12th February 2018

Pre-Application Advice

Erection of 1No. dwelling.

55 Milton Avenue Rustington West Sussex

Existing and Proposed
Site Plans

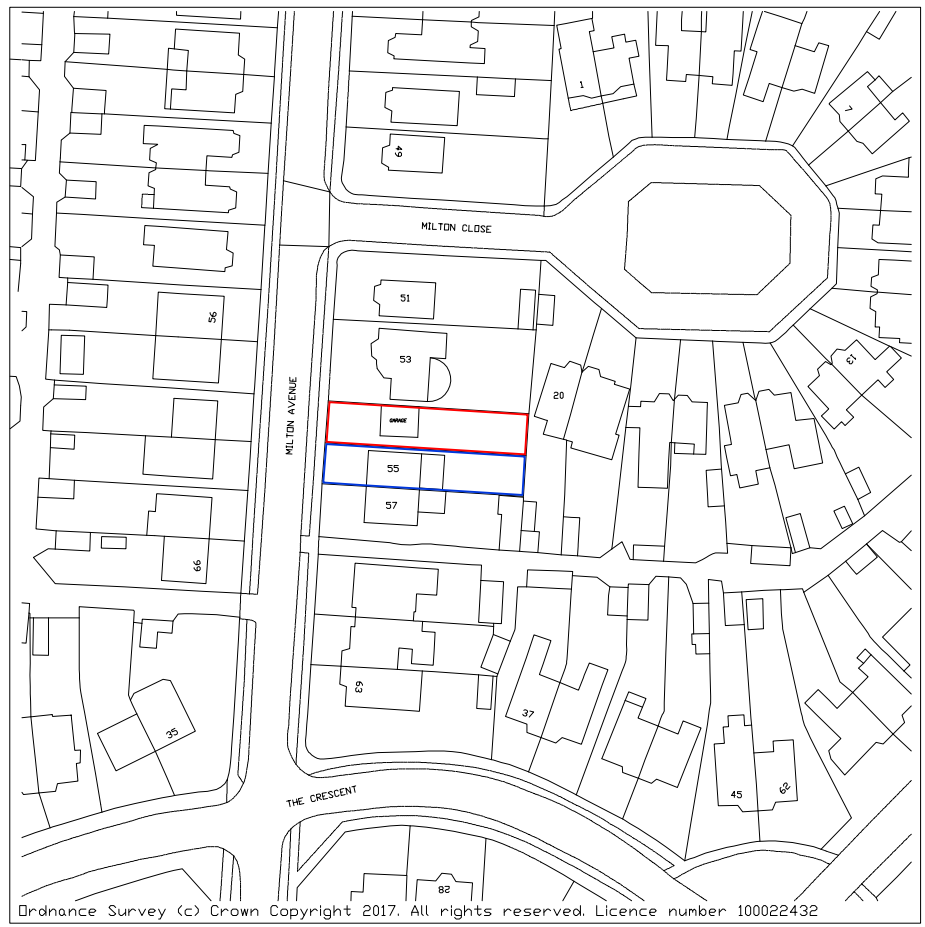
The proposed development is considered unacceptable by reason of conflict with policies and advice. By virtue of the plot width it is considered to have an unacceptable detrimental impact upon the character of the locality. The design of the dwelling has not been submitted as part of the proposal, but given the limited space to site boundaries any dwelling is likely to appear uncharacteristically cramped in the street scene. The proposal would appear at odds and would not reflect the pattern of development in the locality. It is considered that the proposed dwelling would fail to appear integrated with the existing larger neighbouring properties and plot widths.

In this case, it is considered that the proposed development would be unacceptable on the residential amenities of neighbouring properties because the host dwelling has a dormer window facing the application site which has 3 windows facing the site which would lose light and/or outlook and the adjoining property to the north has a first floor room above the garage which would potentially lose light and outlook to the first floor window in the side elevation though it is not evident if this a secondary window.
